Our ref: 25_33677_P

Your ref: H06-0726-25

Site Location: Rozel Marsh Road Gedney Drove
End Spalding PE12 9PL

Summary of Proposal: Demolition of
existing dwelling and erection of 2 dwellings

(Dwg 4275-24-03A)

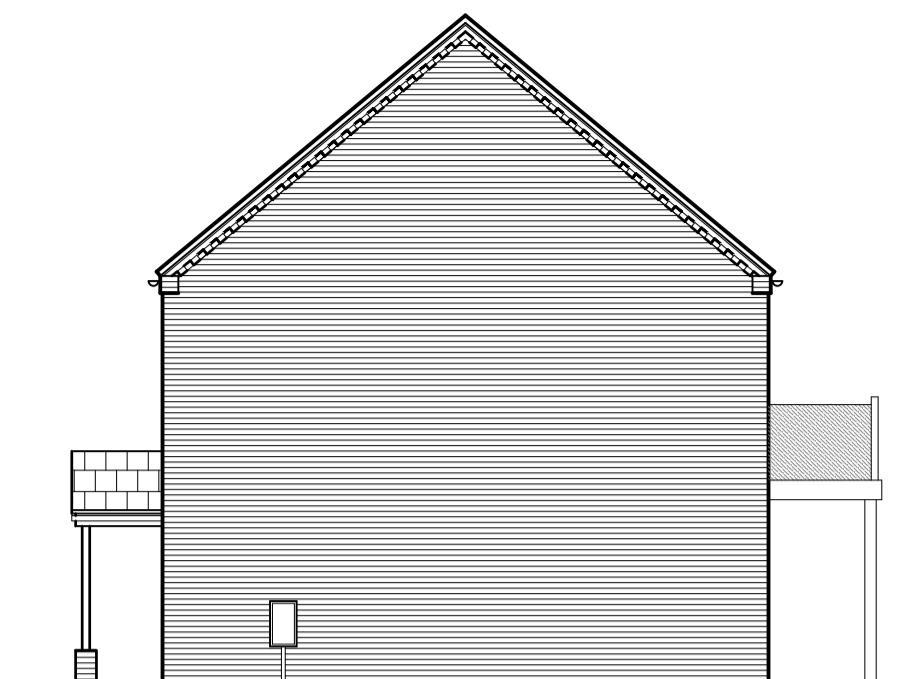
I note that the applicant intends to treat foul waste using a package treatment plan. Within the Site & Location Plans, drawing no. 4275-24 03A (G. R. Merchant Ltd., June 2024) it is indicated that the applicant intends to discharge the treated foul water from the treatment plant to a soakaway. Please note that the applicant must ensure that the system is in line with the [General Binding Rules for Small Sewerage Discharges](#). Should the applicants' proposals change to include the discharge of treated foul water to a watercourse, consent would be required under Byelaw 3. Please note that any consent granted for the discharge of treated foul water is likely to be subject to a Treated Foul Water Development Contribution fee (TFWDC) as outlined within our [Development Control Charges and Fees](#).
